## Department of Industry

OUT17/45685

**Oakdale West Industrial Estate, Kemps Creek, Penrith (SSD 7348)  
Comment on the Environmental Impact Statement (EIS)**

Figure 8 Plan showing riparian corridor widths for Oakdale West Precinct

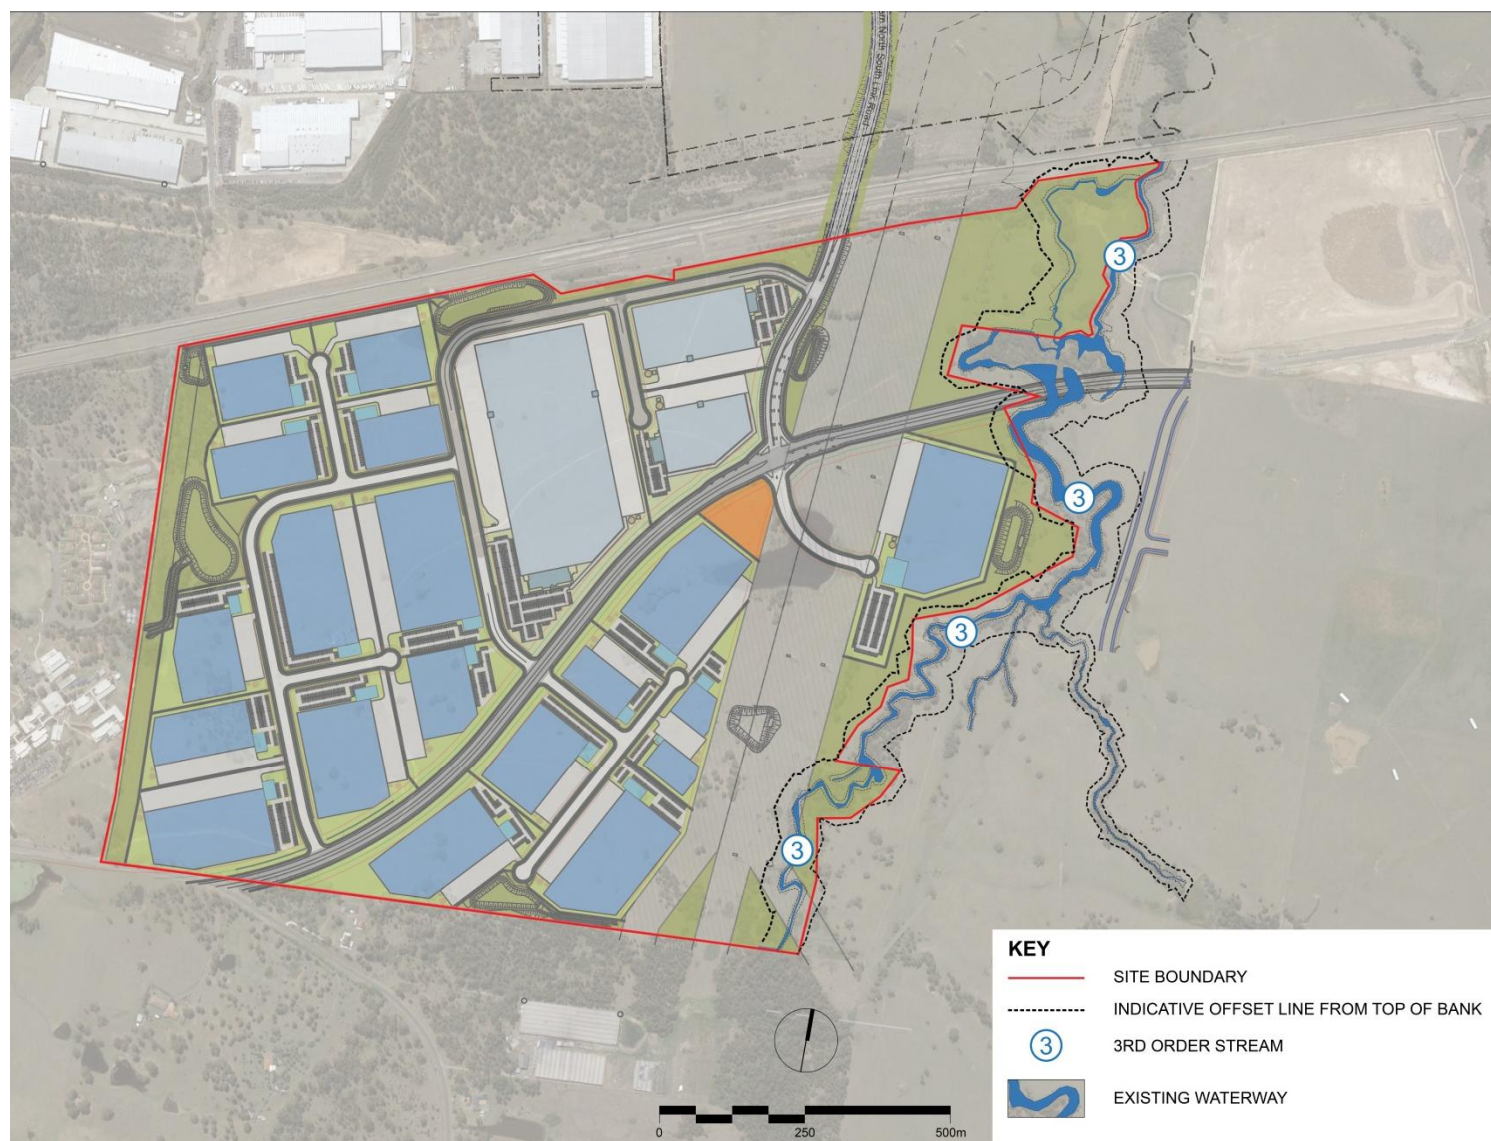
- The proponent should provide a draft vegetation management plan.
- Section 2.4 of the Riparian Corridor Assessment (Soils) refers to Appendix C in relation to the restoration of existing remnant riparian vegetation but there is no information provided in this appendix (or any of the other appendices to this assessment). The proponent should provide this information.
- The proponent should ensure all works on or adjacent to waterfront land are carried out in accordance with the Guidelines for Controlled Activities on Waterfront Lands (2012)
